MP 08_0016 Mod 1, 133 – 145 Lenore Drive, Erskine Park

Response to Agency Submissions

**SP 4**

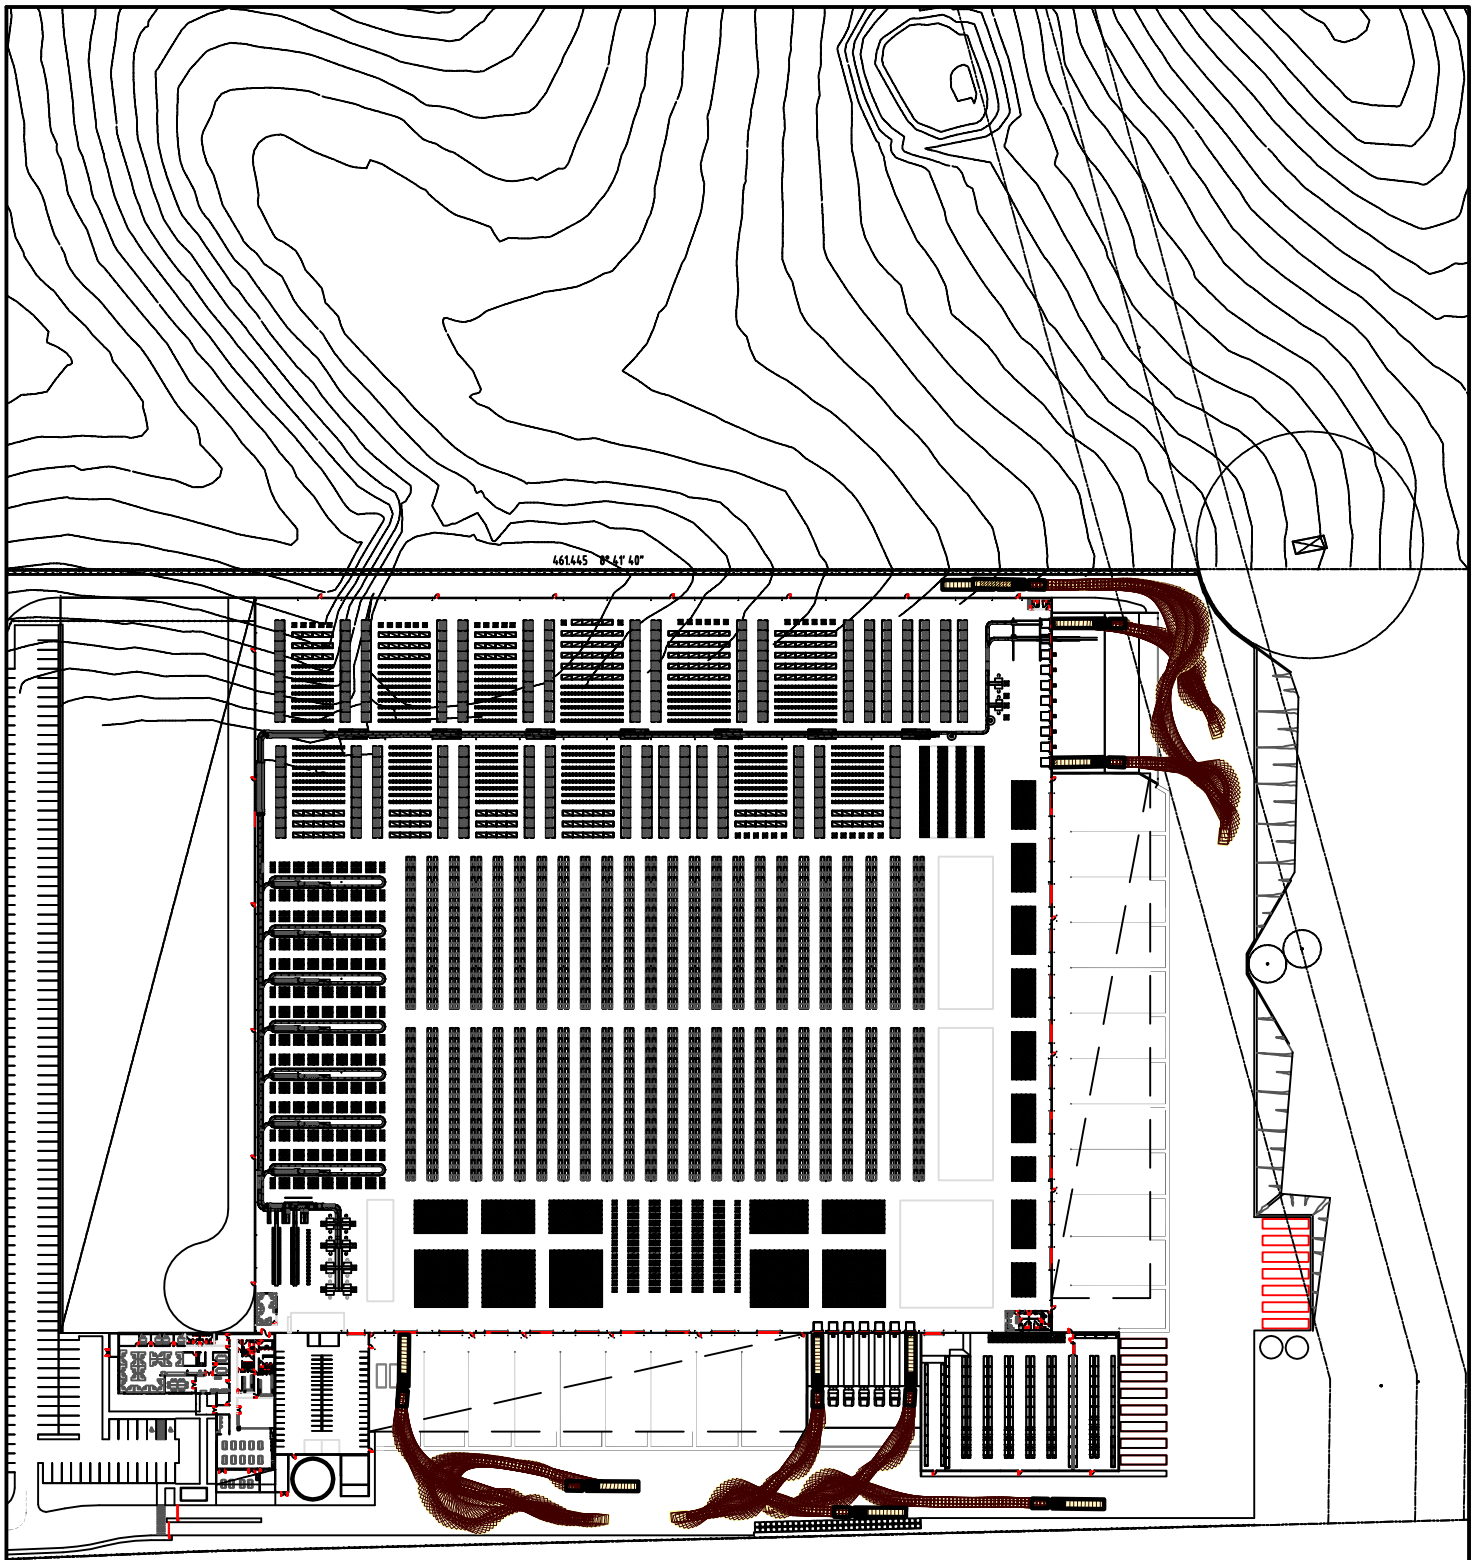
- Provision of directional line marking and signage be provided. - Provision of bicycle parking and facilities (including showers, change rooms, lockers). - Truck access points should be located to accommodate the turning path of a B-double for all movements on the correct side of the road/driveway for vehicles entering and exiting simultaneously. - Vehicles must be wholly contained onsite before being required to stop. - All vehicles must enter/exit the property in a forward direction. - All works associated with the development are to be at no cost to the RTA.	- Directional line marking and signage will be provided to guide heavy vehicles, staff and visitors to the appropriate site locations. - The current major project approval requires the provision of bicycle parking and associated facilities. - Driveways will accord with AS 2890.1 and 2 and will accommodate all B Double vehicles. - Truck access points are designed to appropriately accommodate B Double vehicles (refer to Attachment A). - All vehicles will be able to be entirely within the site before stopping and will be able to enter and depart in a forward direction. Truck turning paths showing the satisfactory provision for access movements are provided in Attachment B of this letter). - No costs will be borne to RMS.
